Waddington Parish Council

Ref – Planning application for 43 Waddow View 3/2021/1195

Waddington Parish Council has considered planning application 3/2021/1195 and has the following comments.

PROPOSED SITE BLOCK PLAN

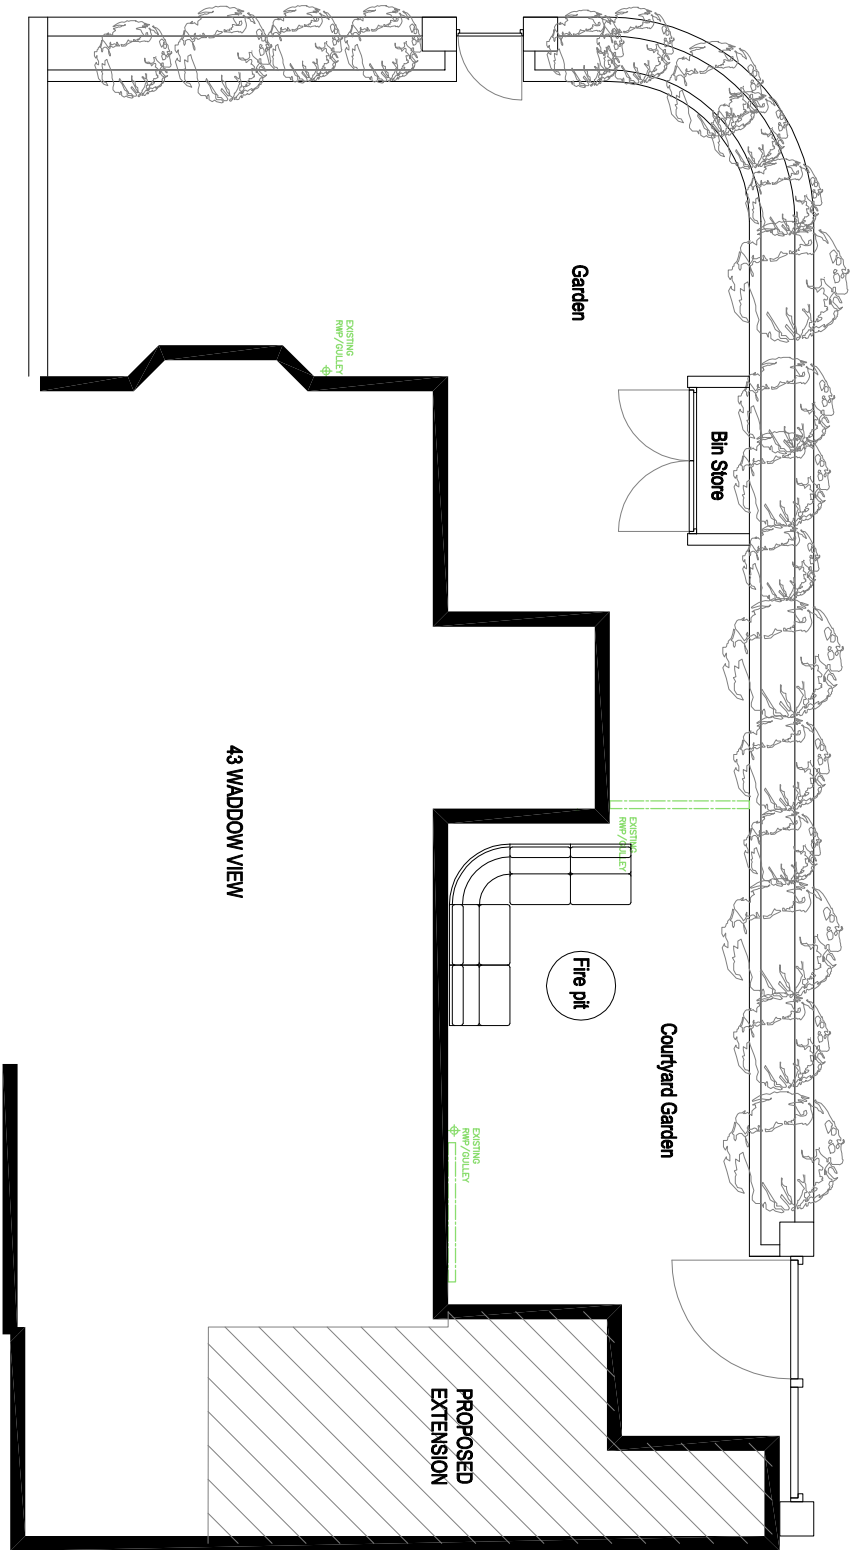
The planning application will remove off road parking, and potentially remove the requirement for the vehicular bridge that was part of the planning application in 2005 (3/2005/0908).

1. As the planning application removes the off-road parking at the property the bridge should be removed to reduce the risk of future flooding.
2. If the bridge is to remain the walls need to be removed/replaced with railings to reduce the flood risk to nearby properties.
3. Request this matter is further investigated by LCC Land Drainage and the Environment Agency.
